City of Albuquerque

REF: Blake's Lota Burger

The referenced drainage plan has been reviewed and the following are my comments:

SITE PLAN
EUBANK & SNOW HEIGHTS

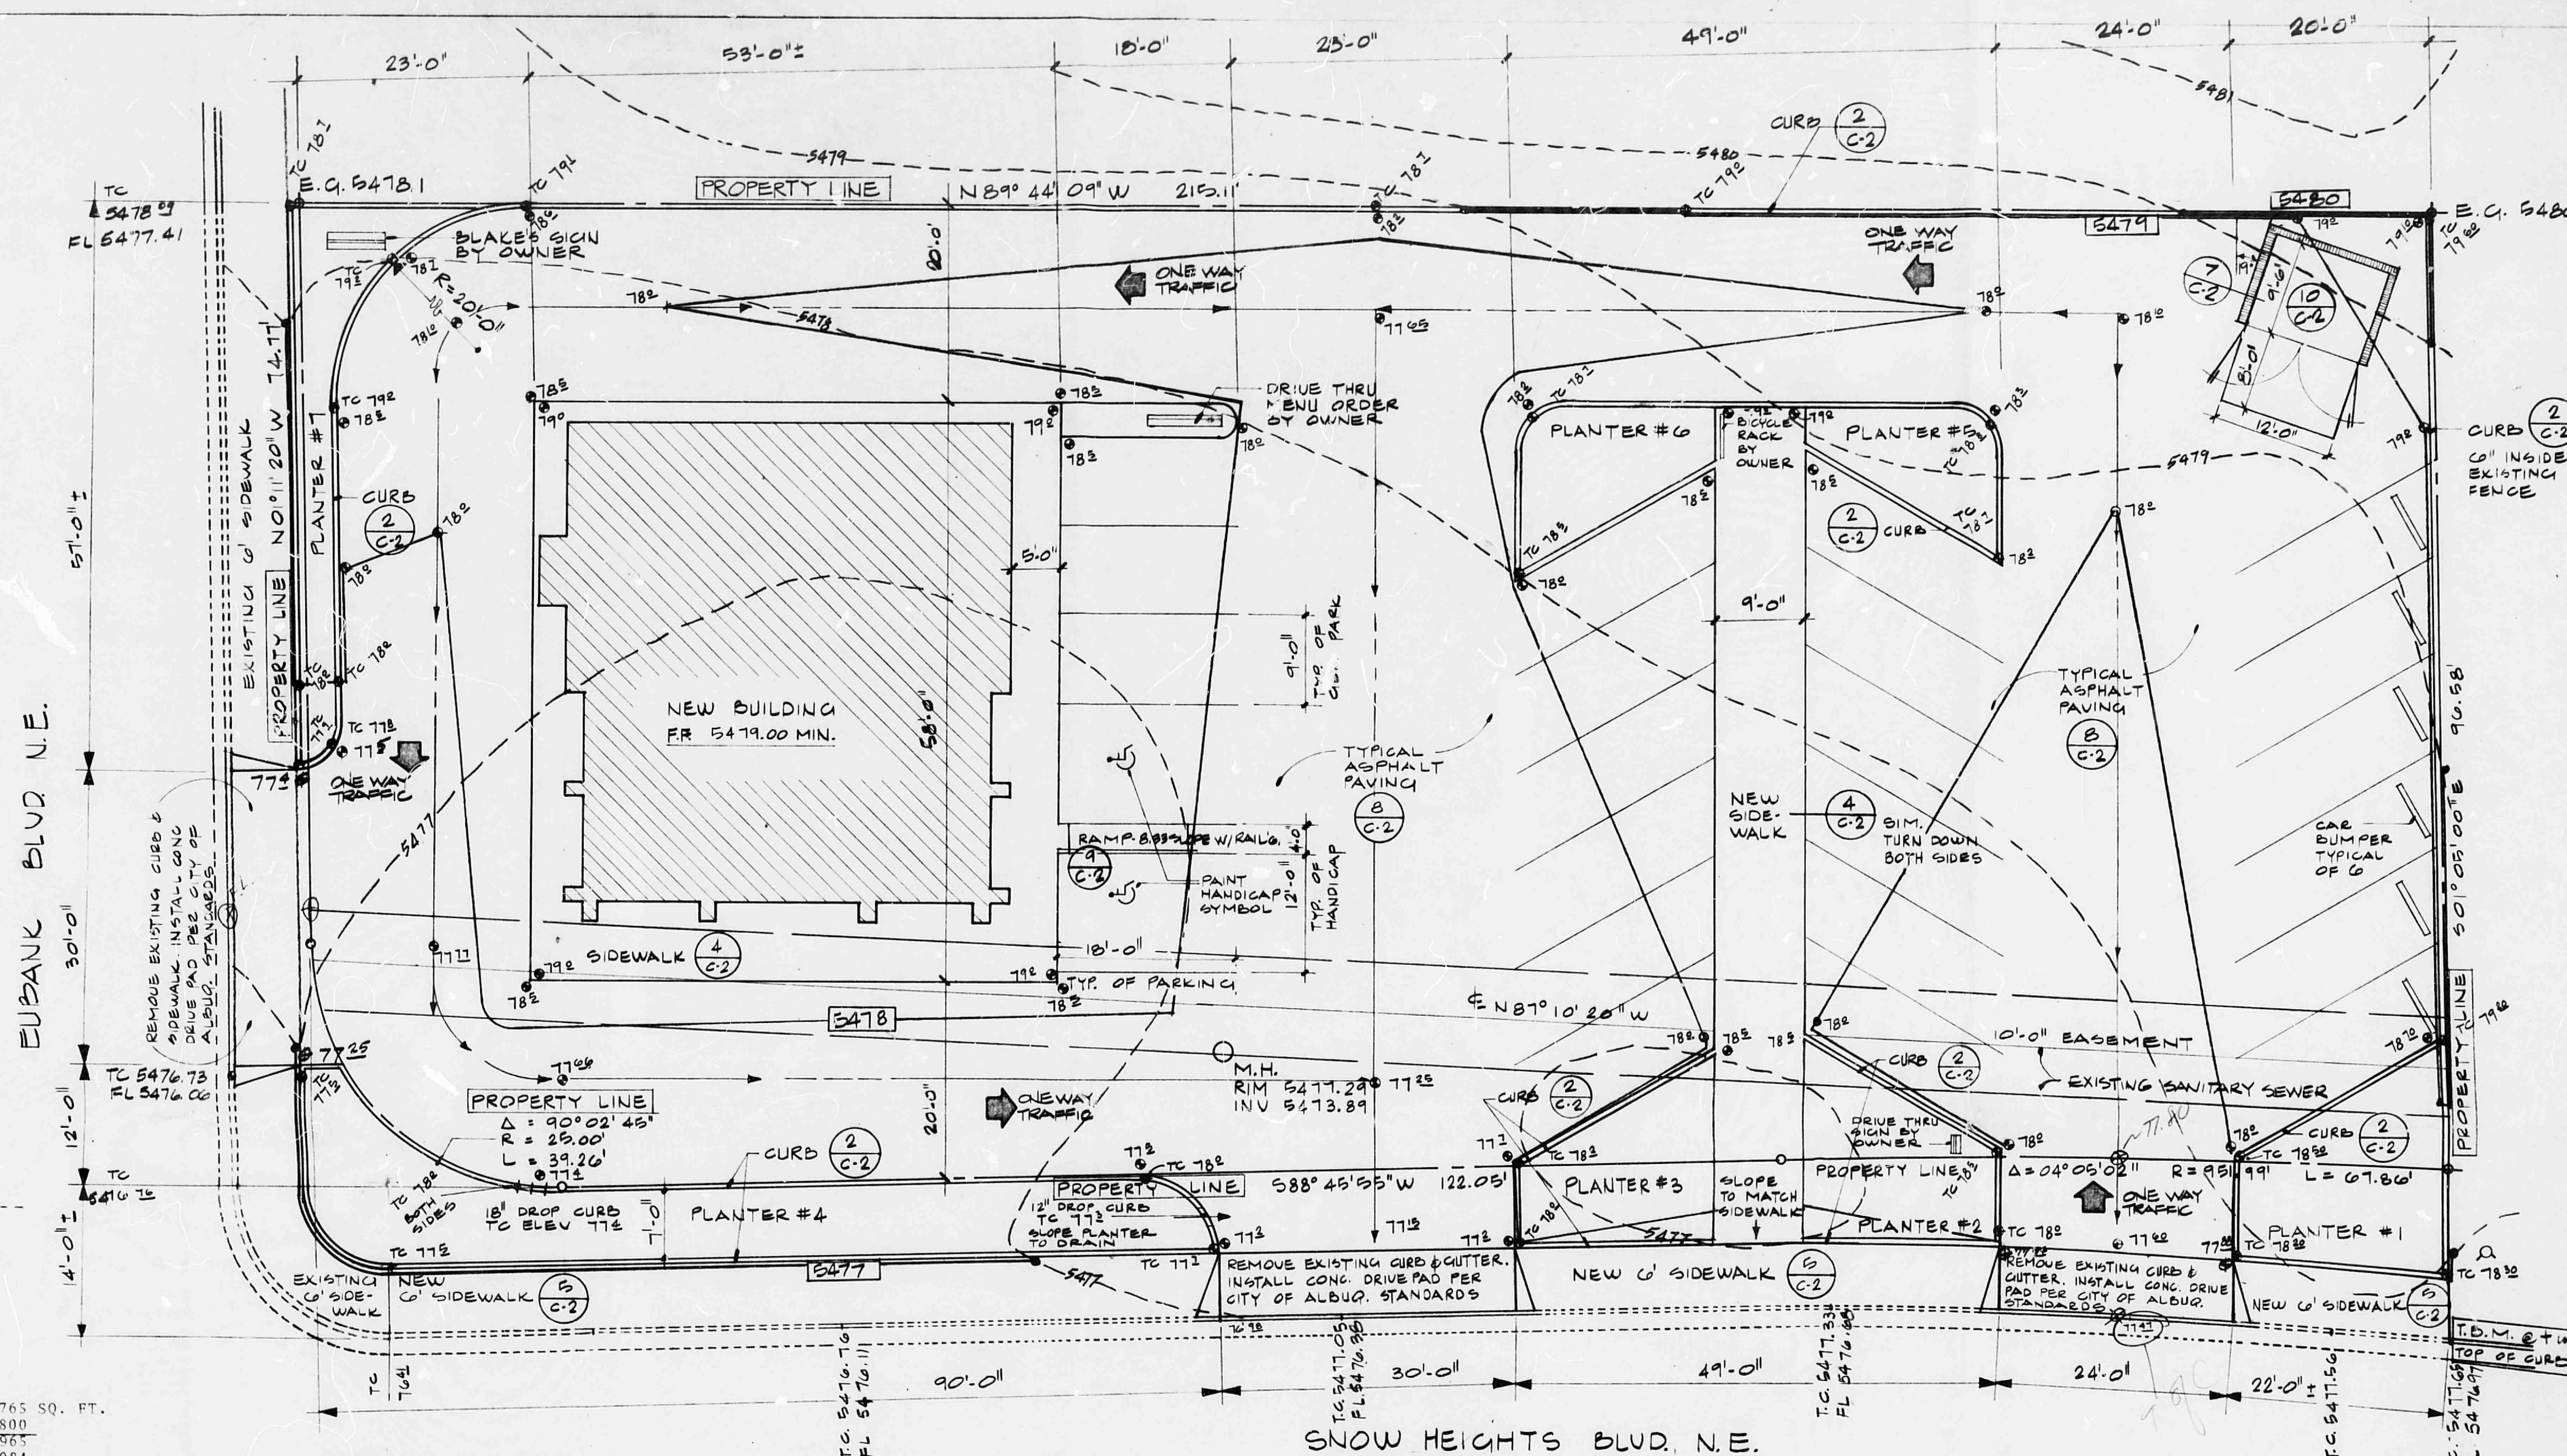
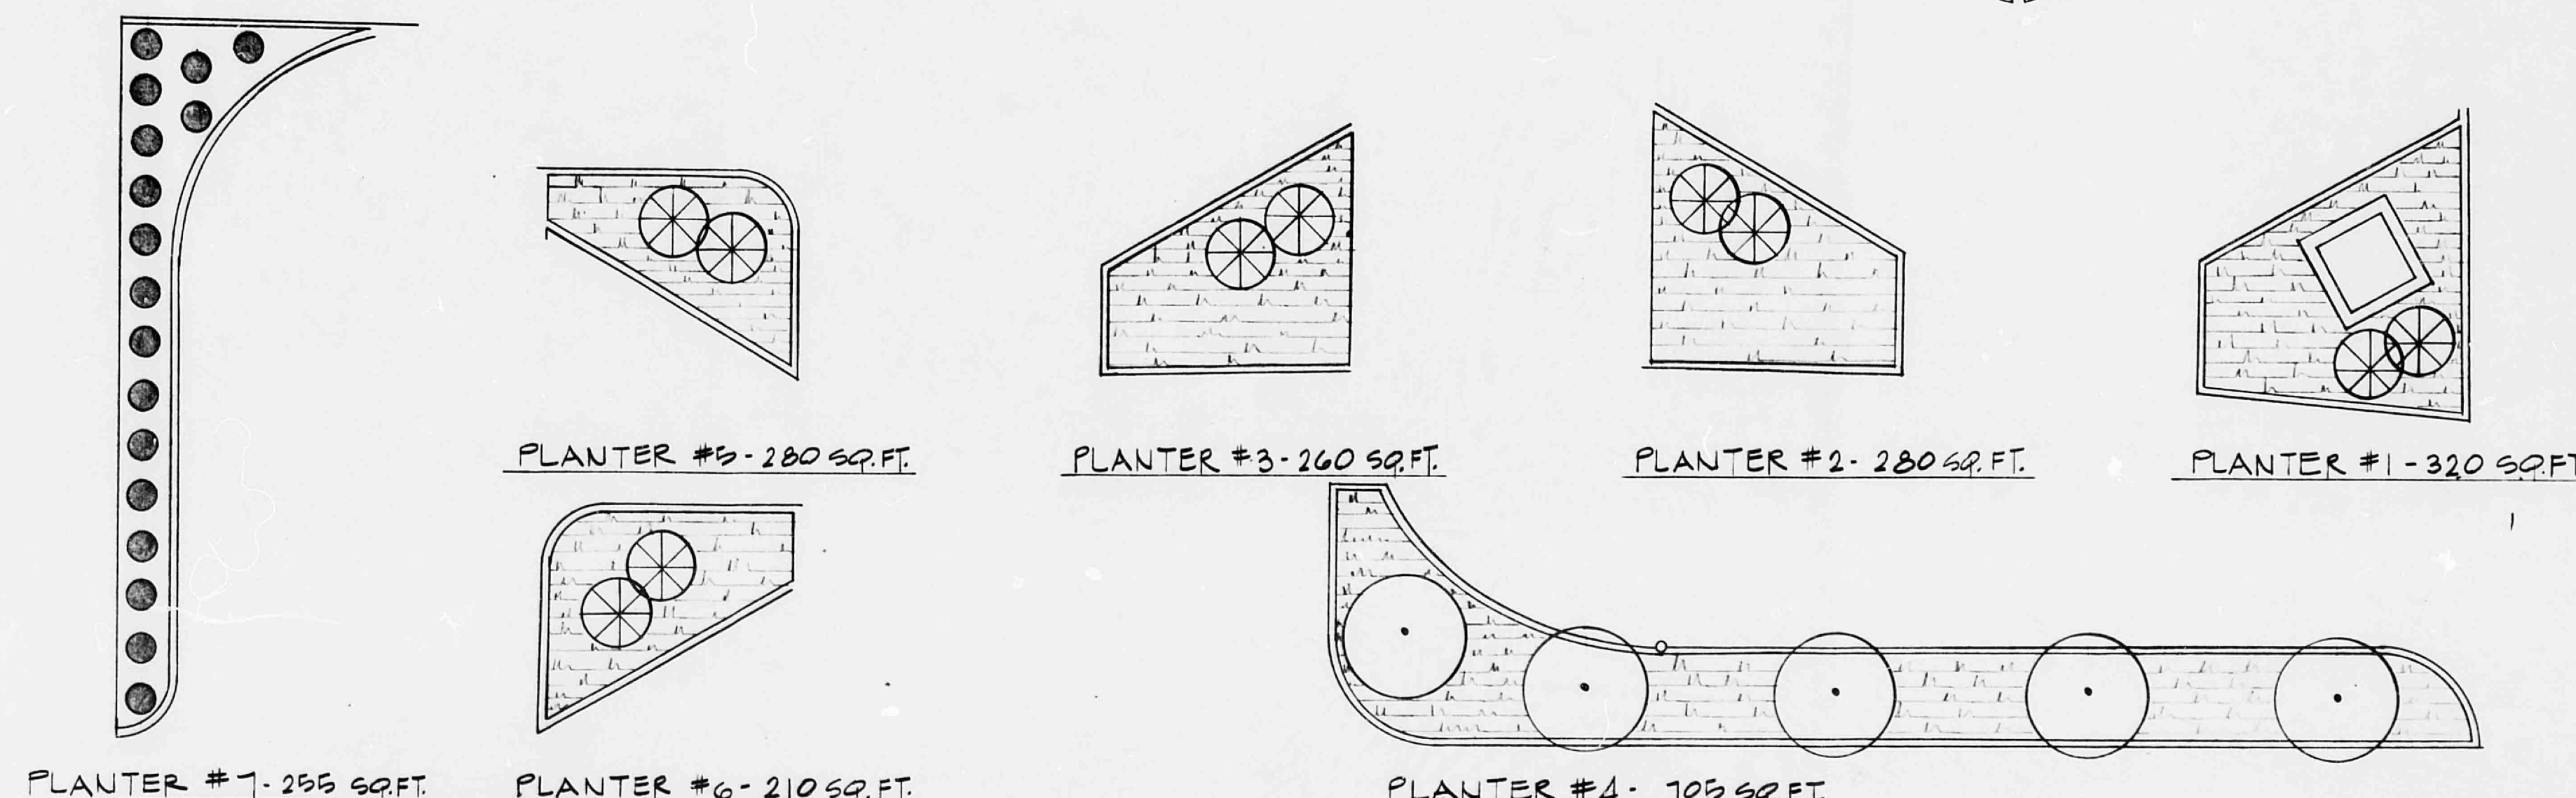
- ✓ 1. Provide a description of the temporary bench mark on-site.
- ✓ 2. Include flow^{LINE}ing elevations with your city top-of-curb elevations.
- ✓ 3. Discuss off-site flows affecting the site and the proposed routing of these flows.
4. Provide the required drivepad elevations on the plan.
- ✓ 5. Grading outside the site's property limits is not allowed without permission from the adjacent property owner.
- ✓ 6. Identify the owner of the drain on-site and the type of drain, z.e., storm drain or sanitary drain.
- ✓ 7. Attach a copy of the latest plat for the referenced site.

I am enclosing a revised print of the referenced drainage plan which has been changed to reflect your comments of May 3, 1983. I also enclose a copy of the latest plat showing Tract 2A-4 of Block 129, Snow Heights Addition.

OFF-SITE FLOWS: As the general area in which the site is located slopes to the west, the primary off-site flow would be coming from the east. There is an intercepting concrete-lined arroyo approximately one block east crossing Snow Heights Blvd. which has the capacity to carry off almost all off-site drainage water before it reaches the Menaul junction. A new storm drain system is to be constructed north to south in front of the site along Menaul which will collect the remaining off-site flow.

The lot adjacent to the site to the east drains to the south and onto Snow Heights - thence east for a half block to the arroyo. The lot immediately north of the site drains west to Menaul where the new storm drain will collect all of the runoff.

The effect of off-site drainage will have no effect on the proposed site.
